Your reference :
Our reference : EF13/2738; DOC18/143455-01
Contact : Mr Allan Adams; (02) 6332 7610

26 March 2018

Re: Cadia East Project MOD 10 – Molybdenum Plant Relocation

Figure 3

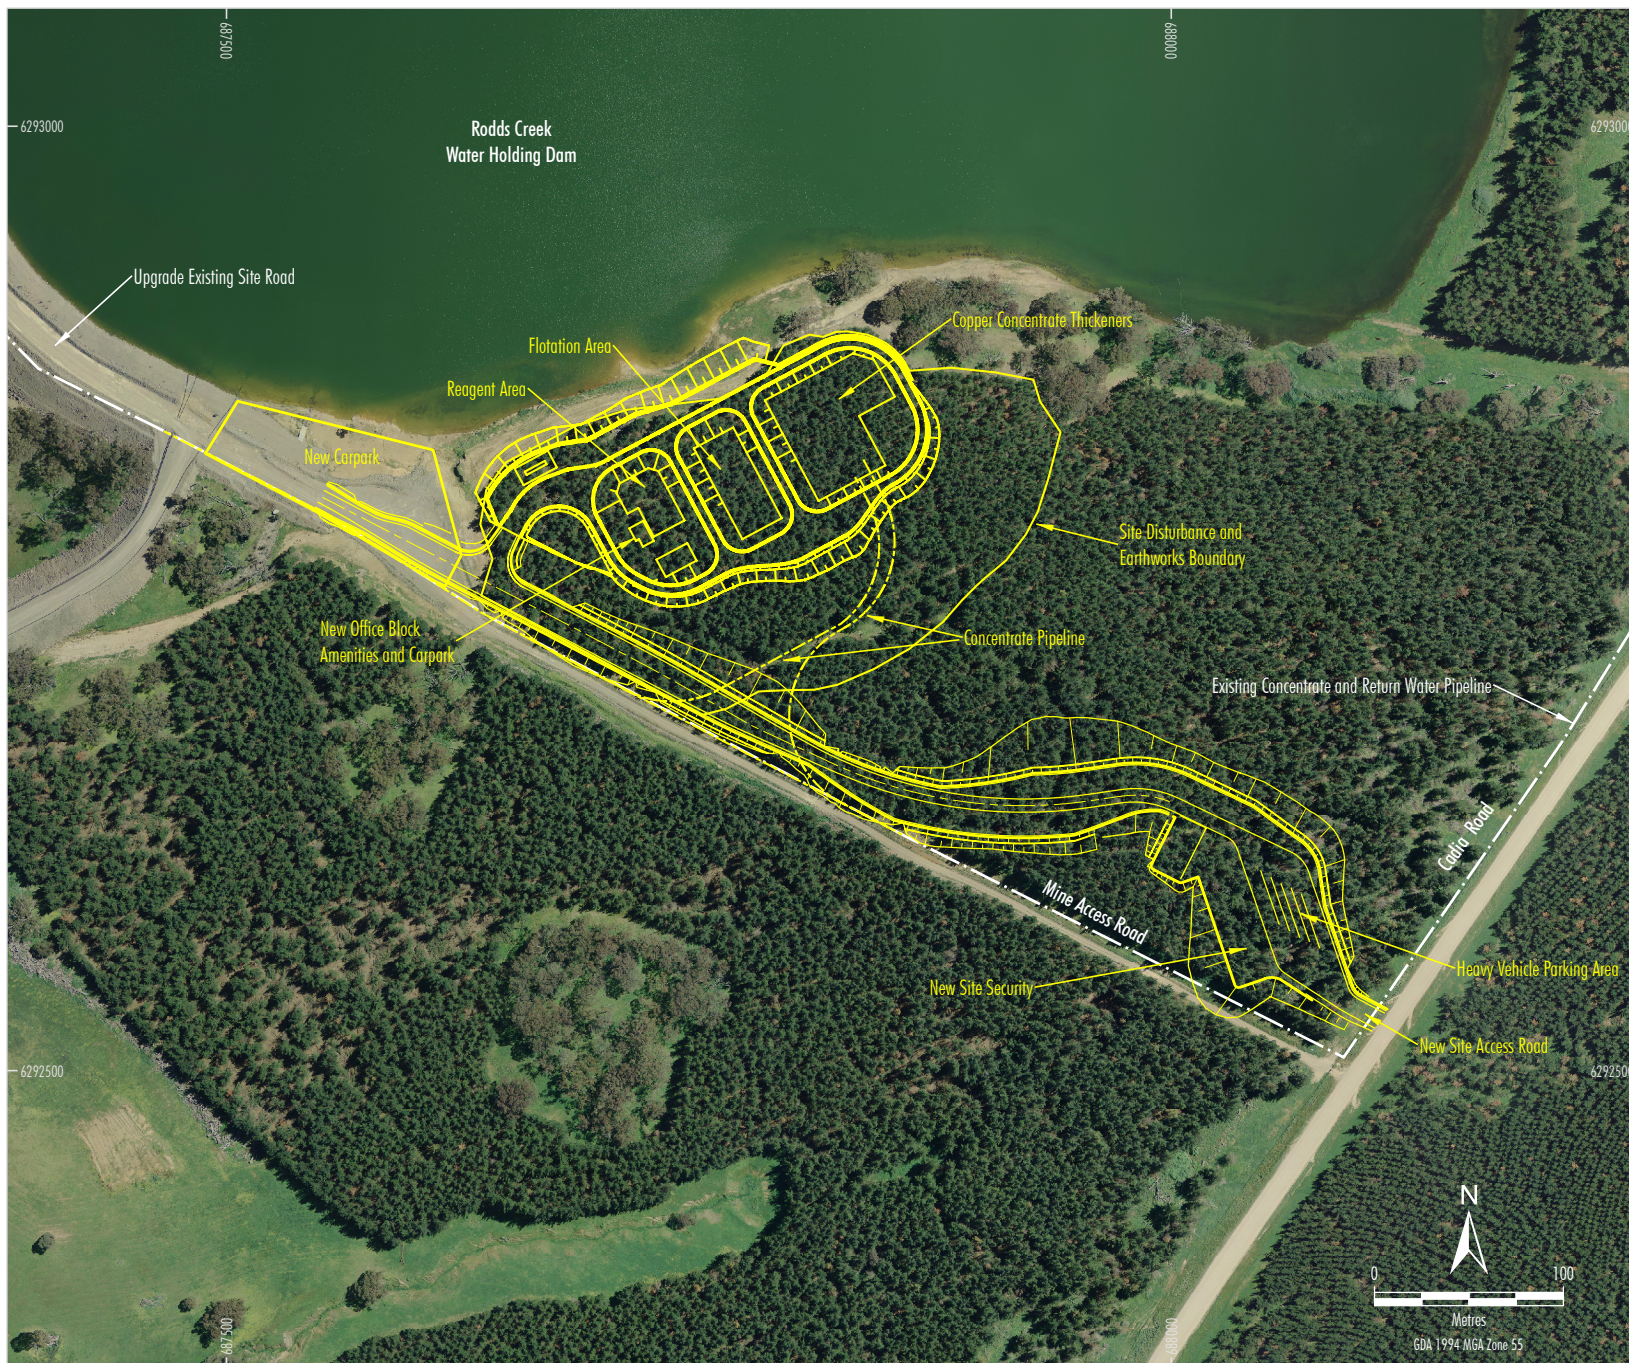
The EPA notes that Figure 2–11 of the Cadia East EA presents a 'moly-dryer', and indicates an exhaust stack, although section 2.7.3 of the EA – Molybdenum Recovery Plant does not present any details of modelled or projected emissions from the stack/plant. The EPA therefore requests that CVO provide information that any emissions from the Molybdenum Recovery Plant are not captured by Schedule 3 – Standards of concentration for scheduled premises: activities and plant used for specific purposes under the *Protection of the Environment Operations (Clean Air) Regulation 2010*.
